SICEEP, SOUTH EAST PLOT (SSDA9) – CONSOLIDATED AGENCY RESPONSE TO SUBMISSIONS

Image 1.19 FJMT-DA-R1002 [07] L00 Podium Ground.pdf

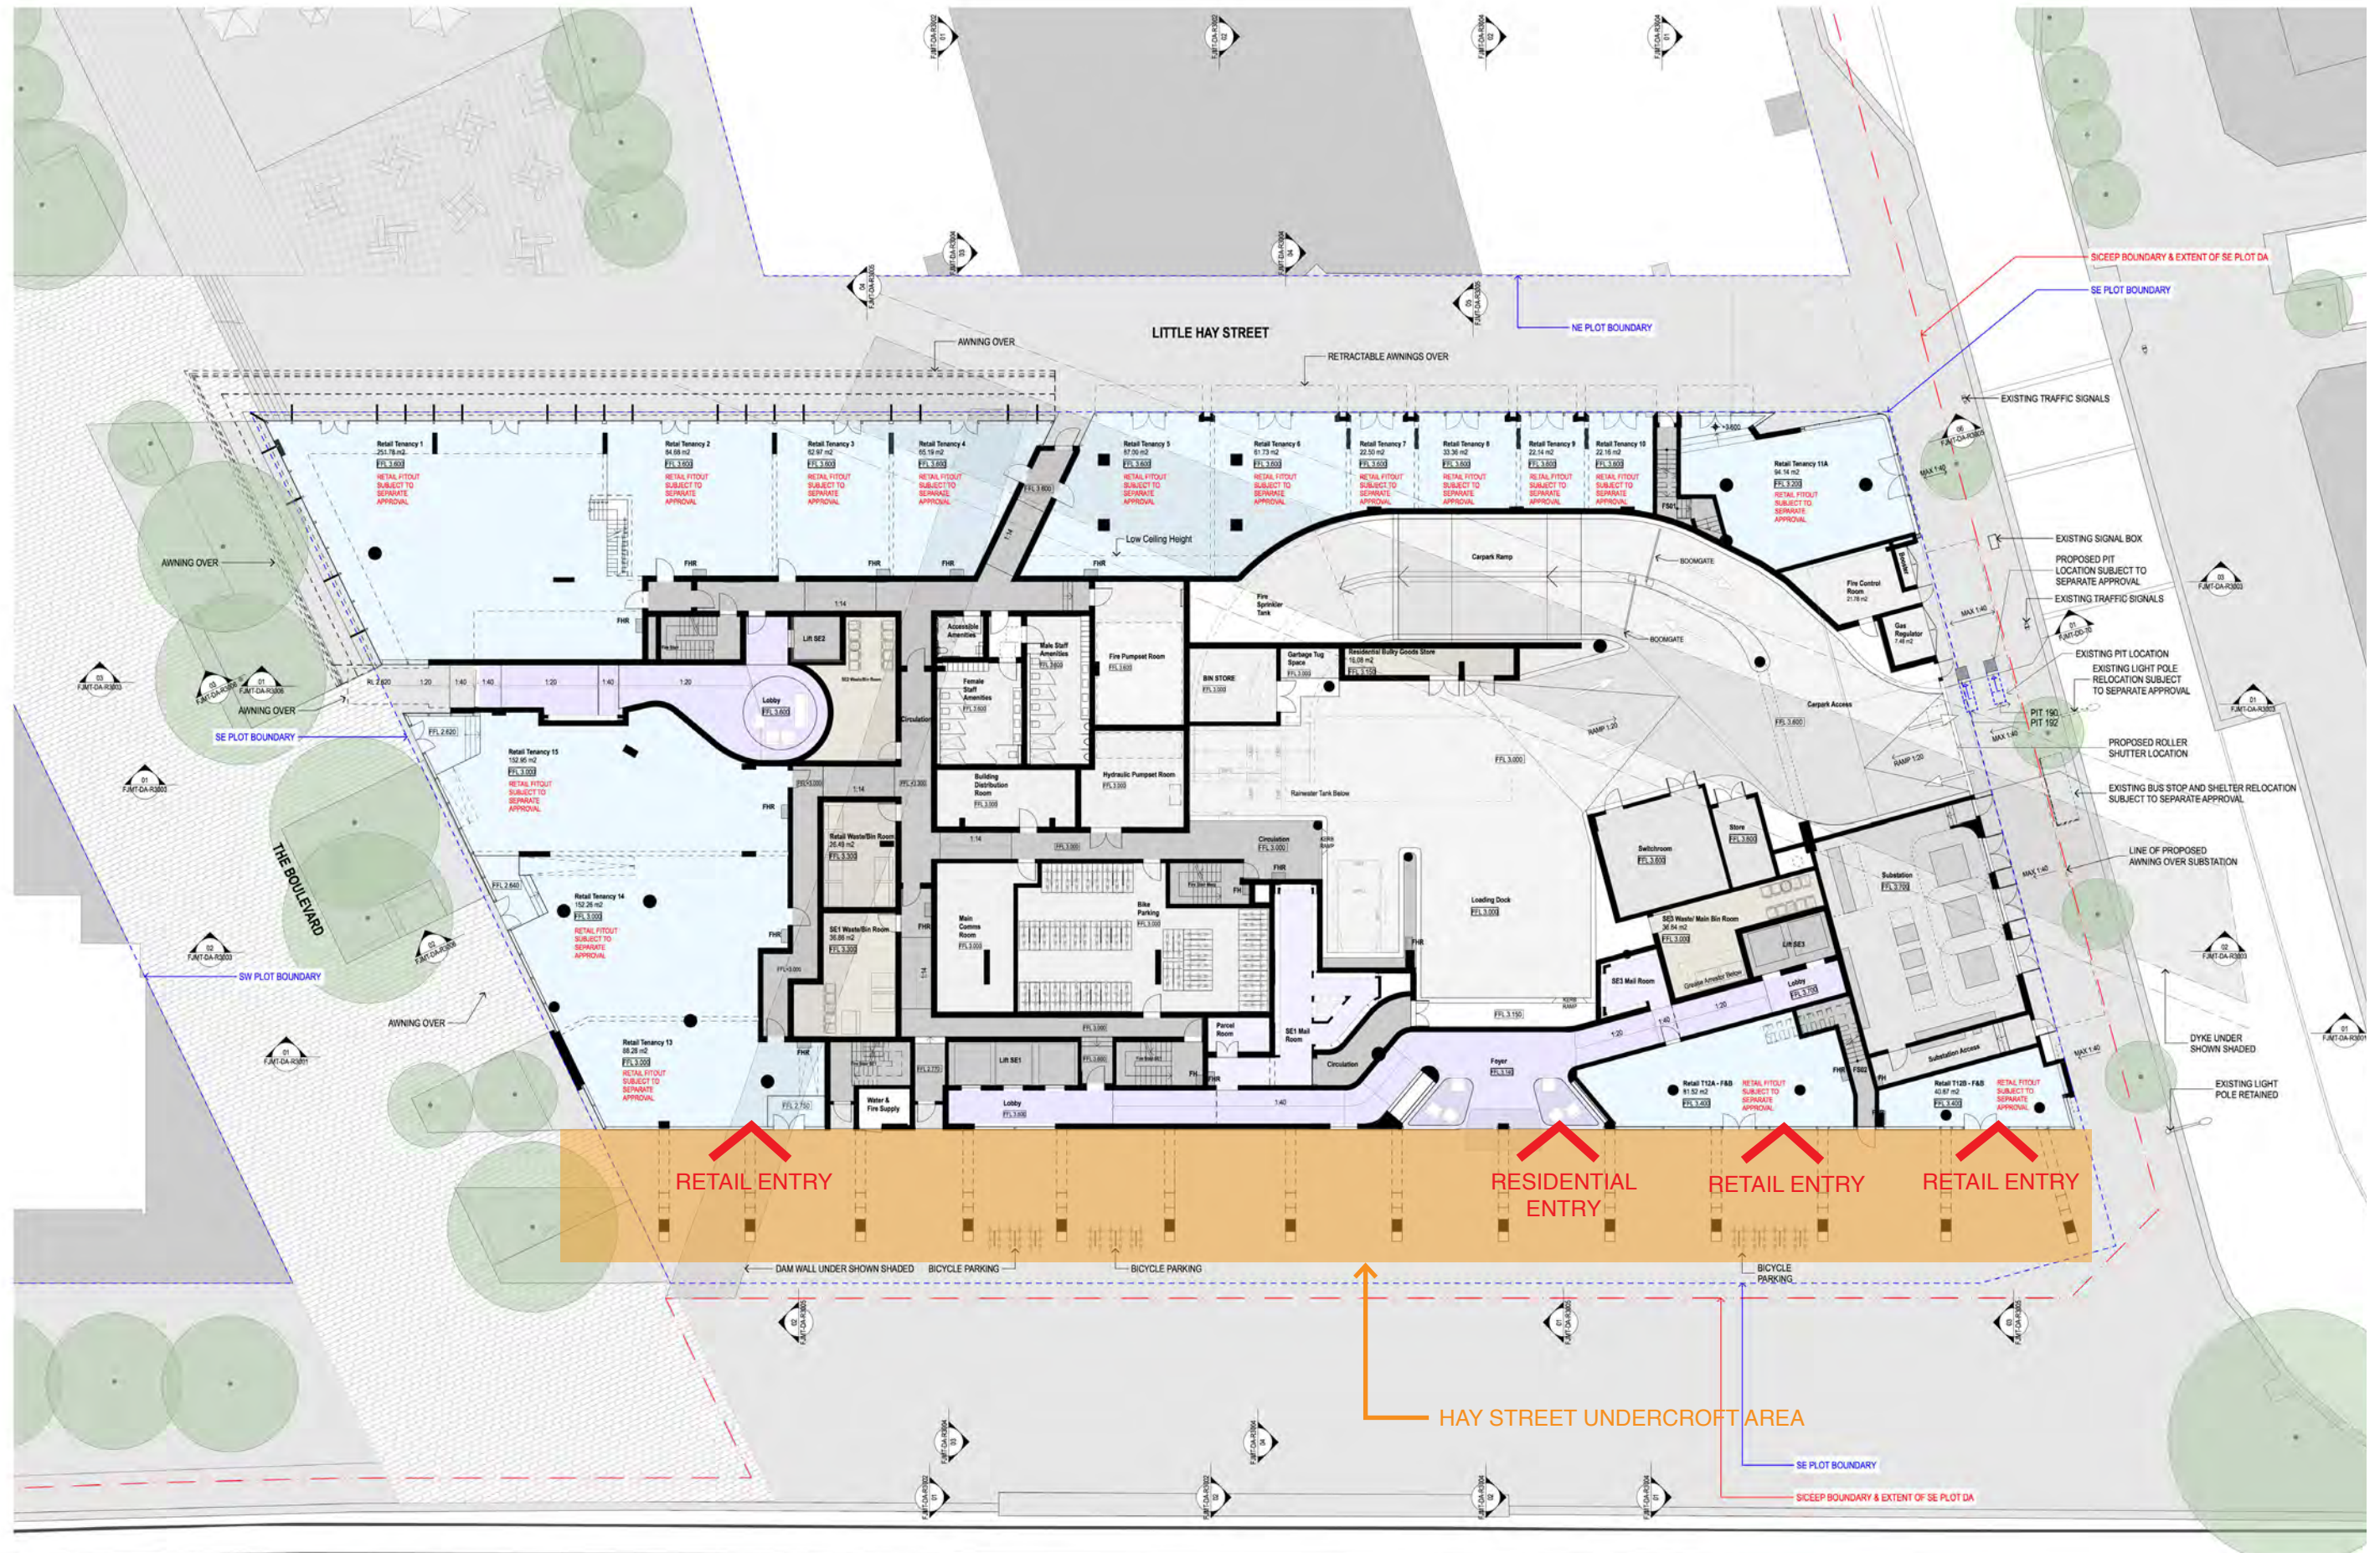
Key Issue		Response
Department of Planning and Environment		
Public Domain / CPTED		
1	Clarify the proposed use of the undercroft area fronting Hay Street, including what measures will be employed to prevent antisocial behaviour and vagrancy. Consideration should be given to increasing the active uses or other alterations to define this space and give it purpose.	The undercroft is principally required to enable overland flow and the construction of a culvert along Hay Street in a specific location. This stormwater constraint and other technical requirements have necessitated the provision of an undercroft within the South East Plot. The activation of the undercroft was a key design consideration for the precinct. A well activated undercroft will serve as a deterrent to anti-social behaviour and vagrancy. To achieve this activation, pedestrian desire lines along Hay Street are focused as much as possible toward and through the colonnade. The residential lobby for Building SE1 and Building SE3 is located midway along the undercroft and will focus the foot traffic to 362 apartments to and through the colonnade. Two retail tenancies have been located on the corners of the Boulevard and Harbour Street, anchoring the ground plane of the development and encouraging activity in the colonnade space. Activation will be achieved by providing outdoor dining in the case of a retail food tenancy or dynamic shop front displays in the case of traditional retail. This in combination with expansive glazed retail facades will ensure the space has a sense of activation. To prevent vagrancy, the extent of any 'nooks' along the façade have been minimised to ensure the space is perceived as safe. This principle of safety will be further reinforced through effective lighting in the colonnade.
